Date: April 24, 2018

From: Charles K. Cothorn, P.E.

Subject: Springs at Waterview

This memorandum has been prepared to provide response and clarification to the GMS letter dated February 22, 2018. The comment is listed followed by the response. Please find attached 3 sets of the revised plans for the above referenced project for your review along with a copy of the plat. One of the sets and a copy of the plat has been provided to GMS, Inc. for their review.

PDF-18 - STORM I & J PROFILES.PDF

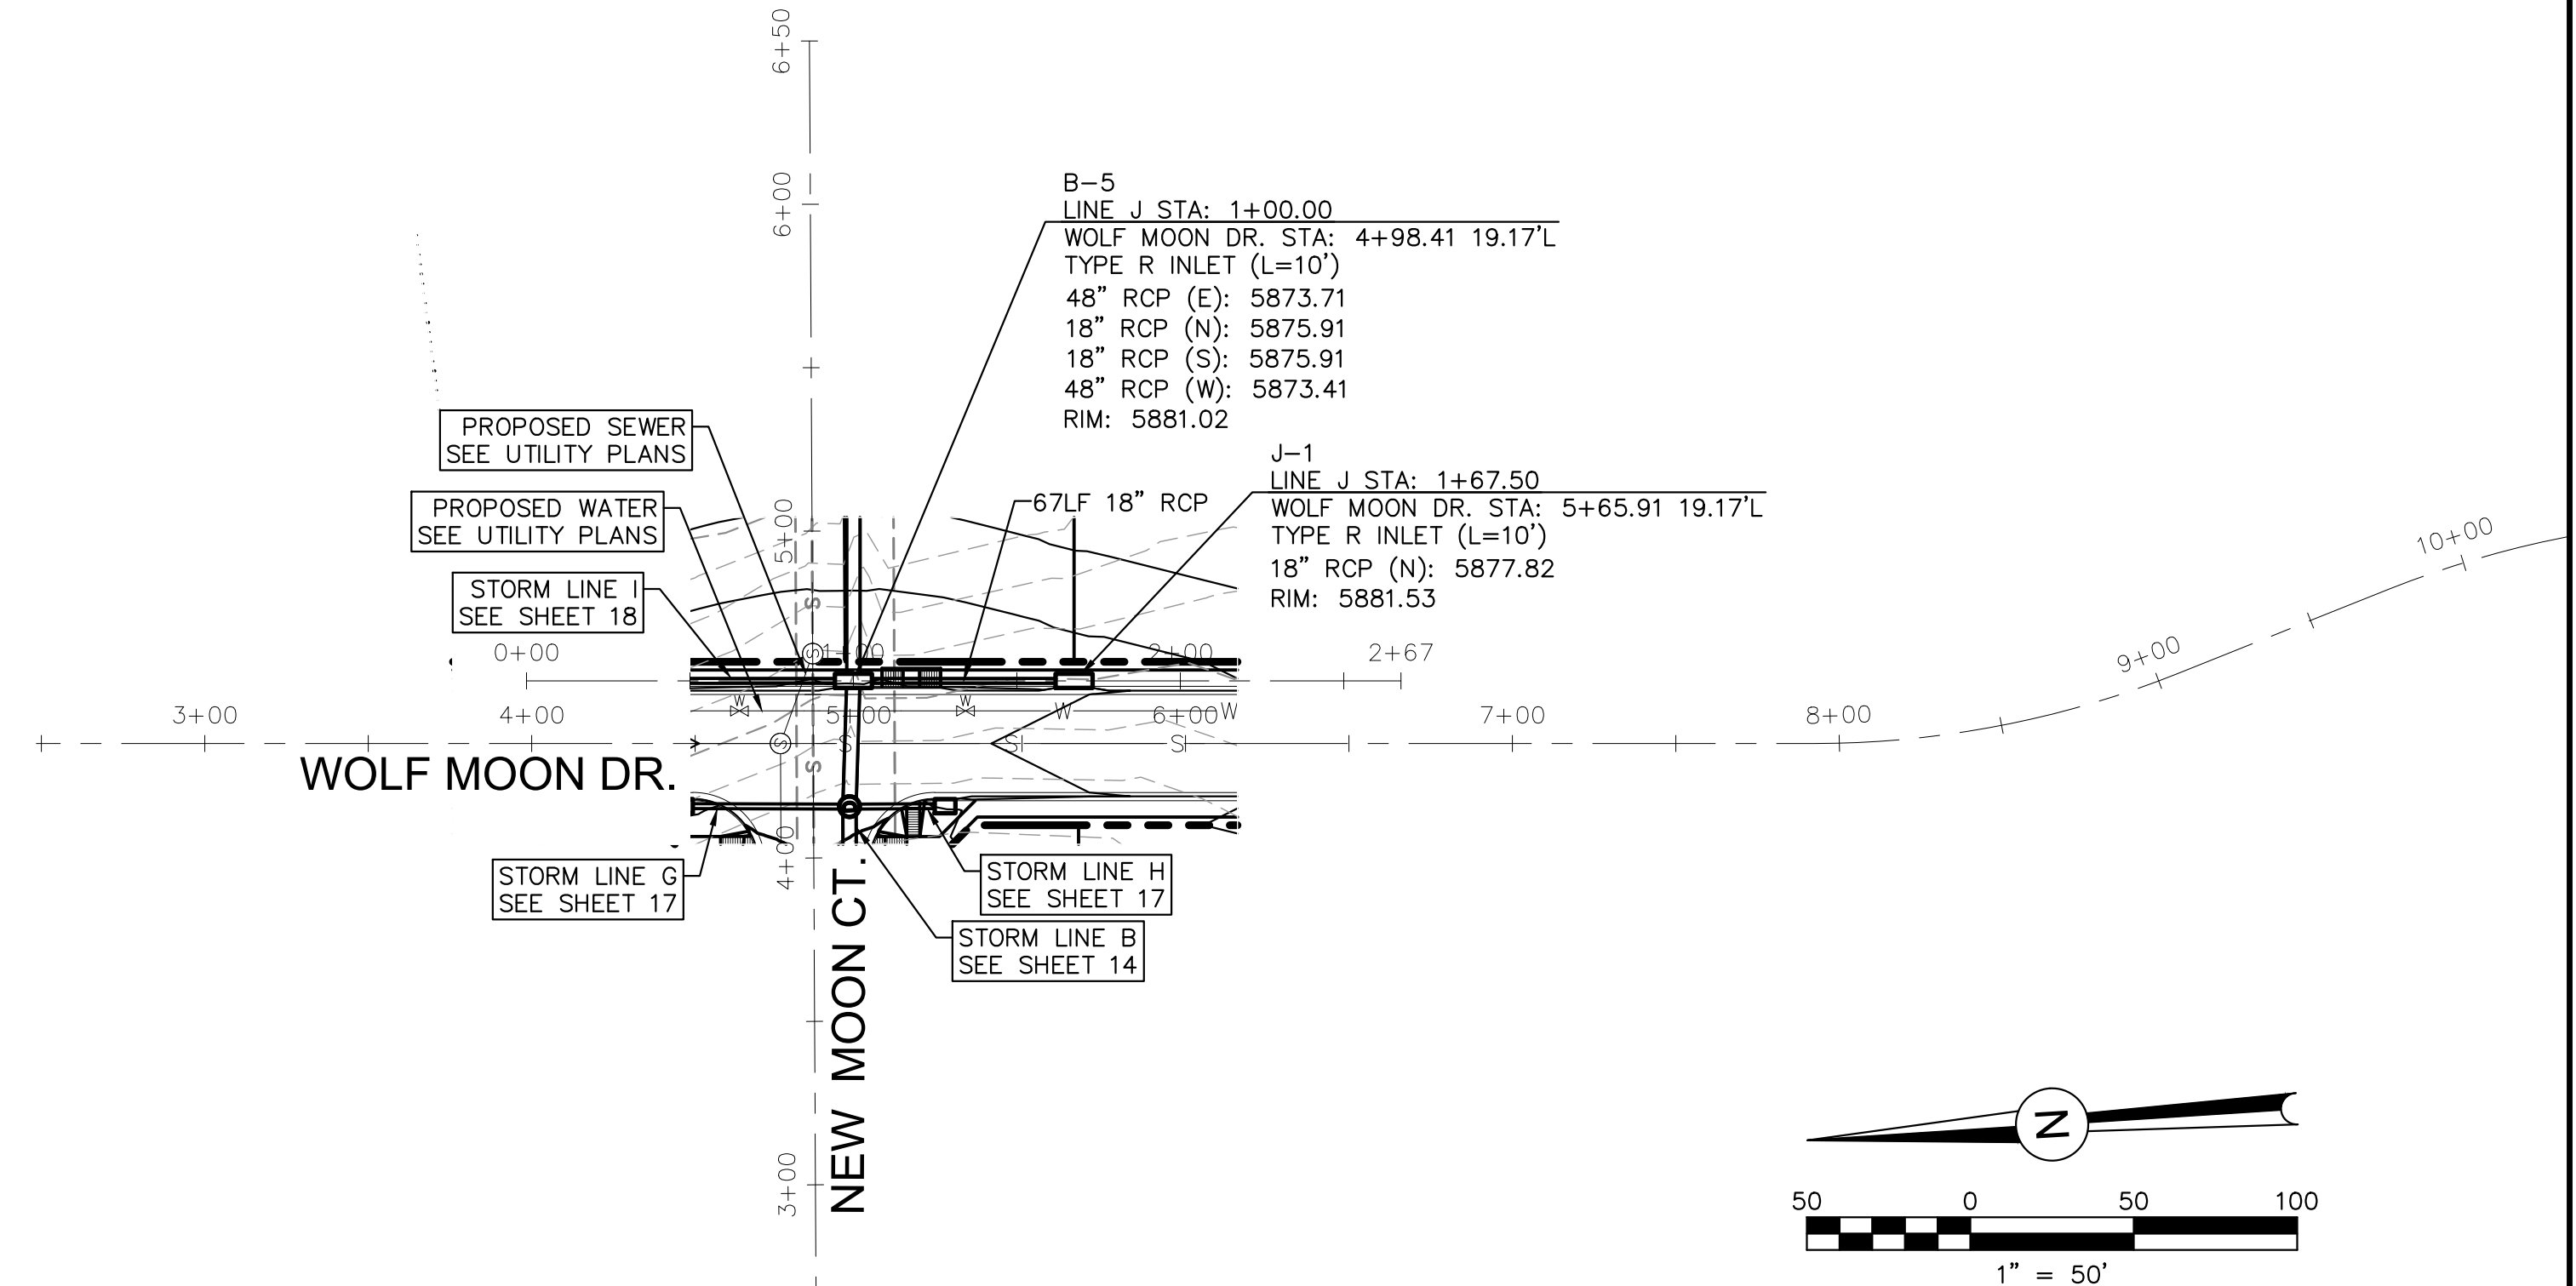
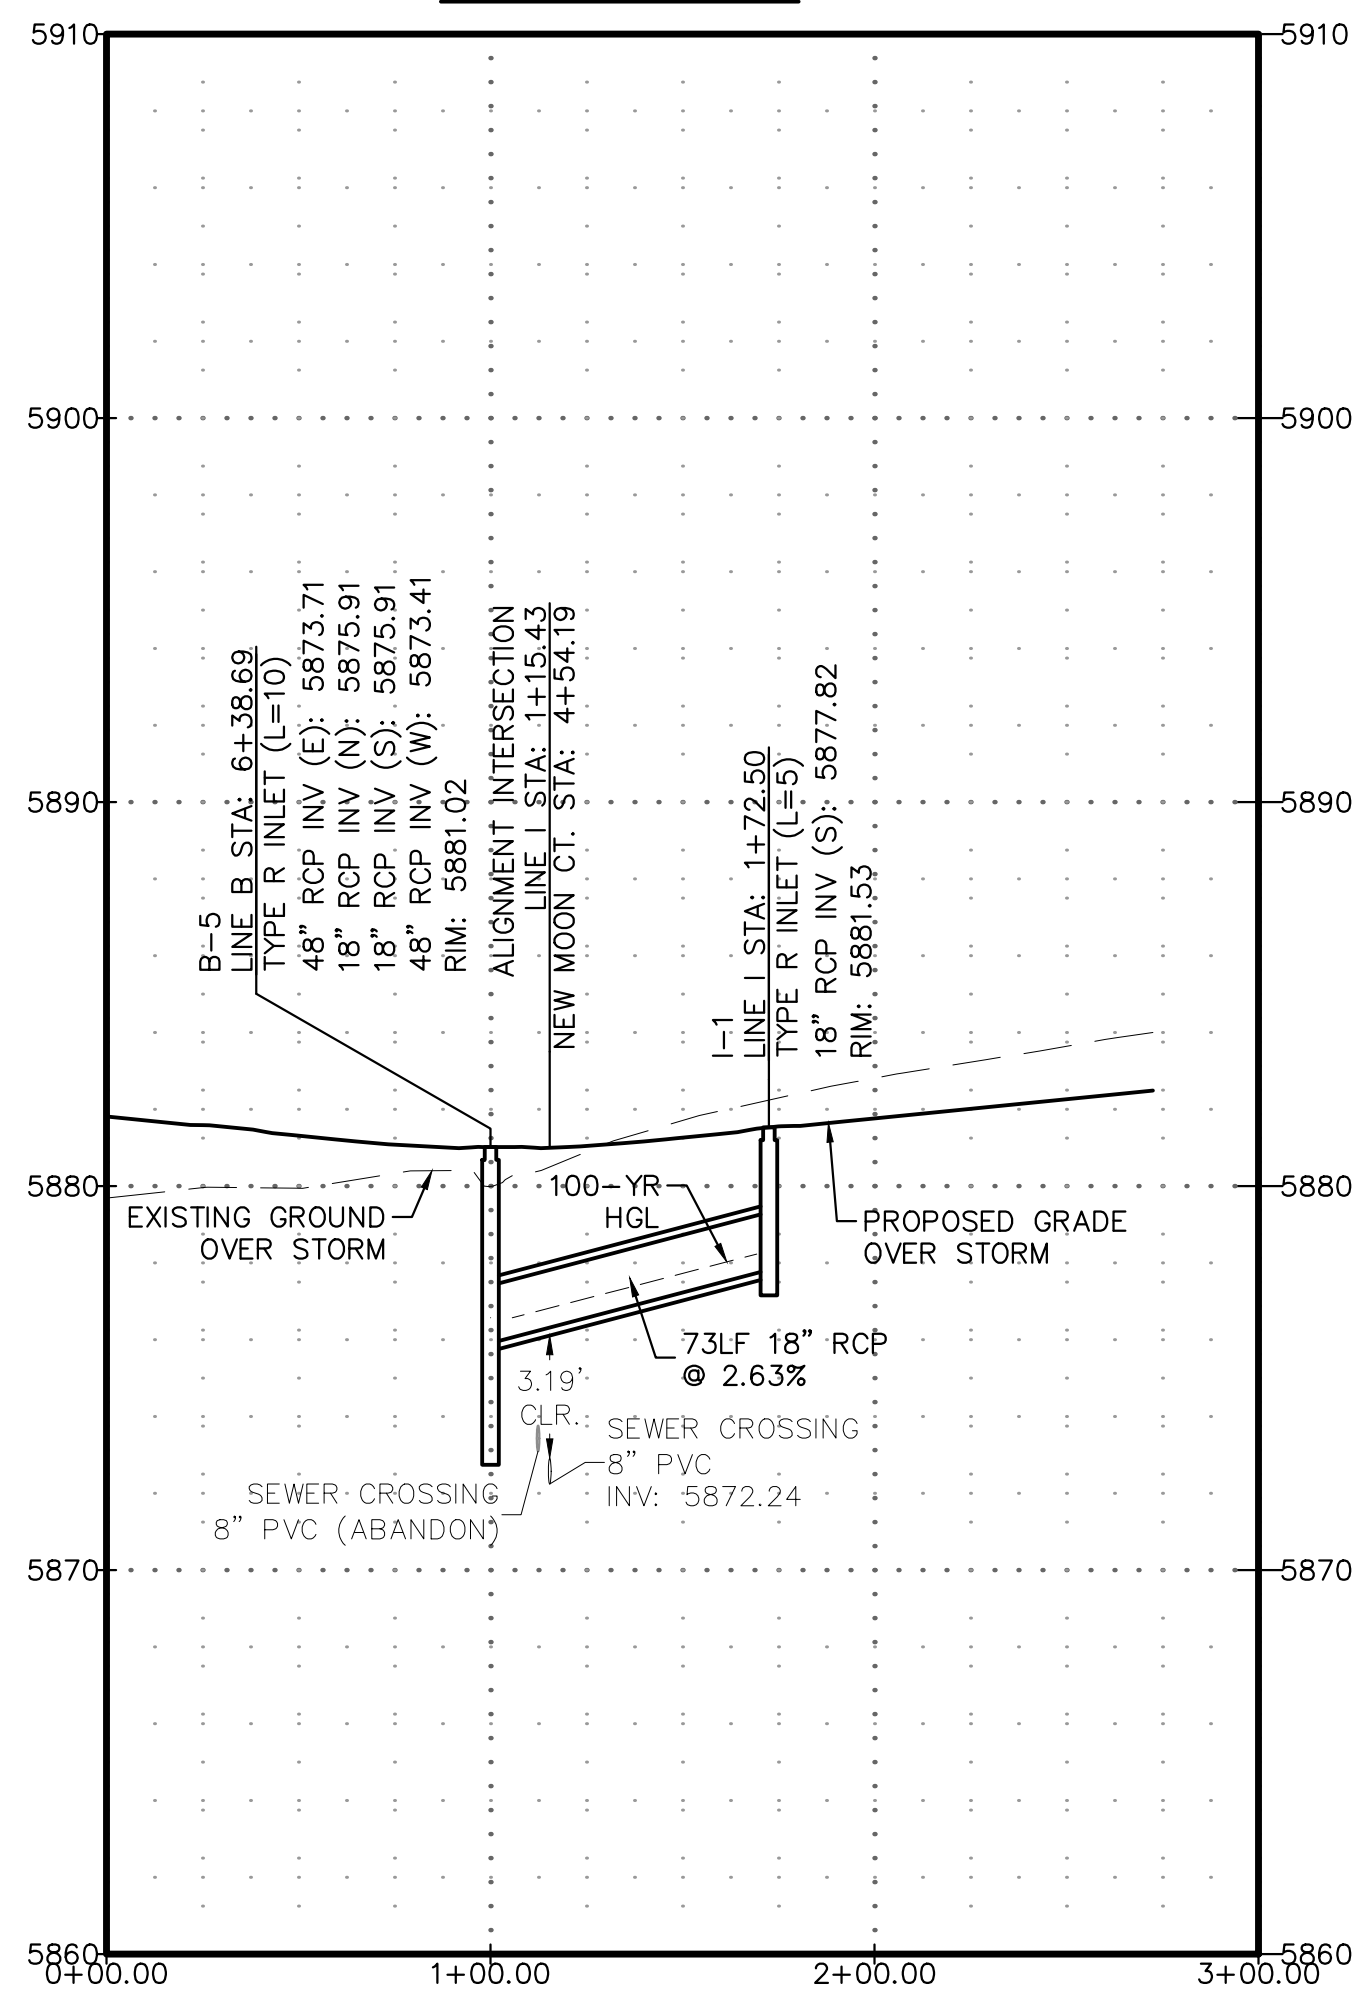
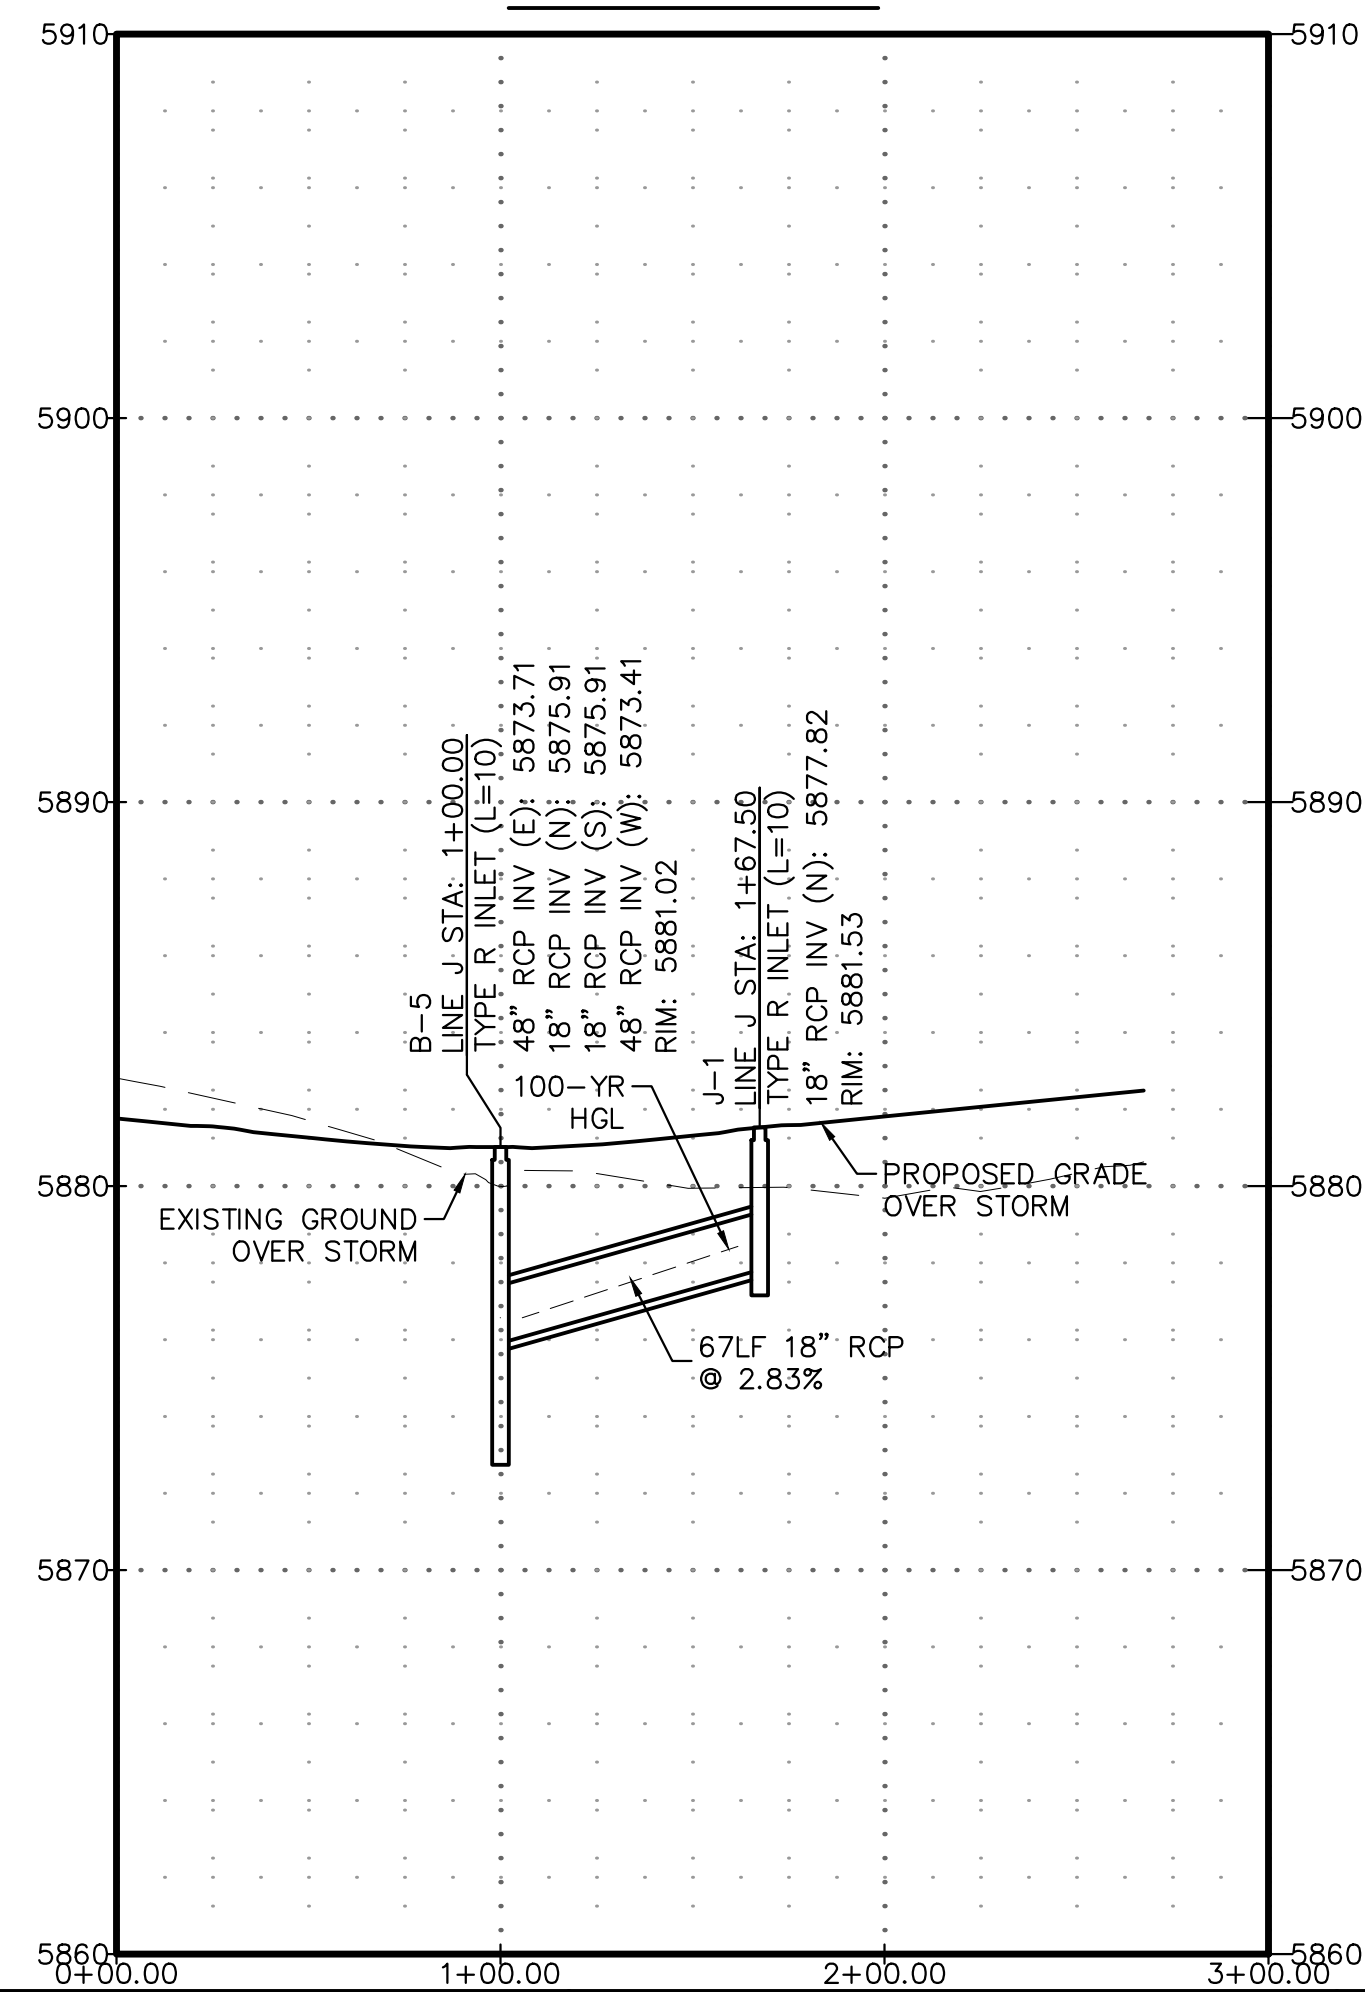
1. In order to comply with the District's water service depth requirements and vertical separation requirements from sewers, please provide and indicate the use of water service sleeves where the water services will cross the Storm Lines Land-J Provide complete construction details.

DSE Response: Water service line callouts added to have service sleeves to be installed on Lots 9-10, 24-26, 49-50, and 71-73. Standard detail for sleeved crossings added to Sheet 5 of 11, titled Master Utility Plan.
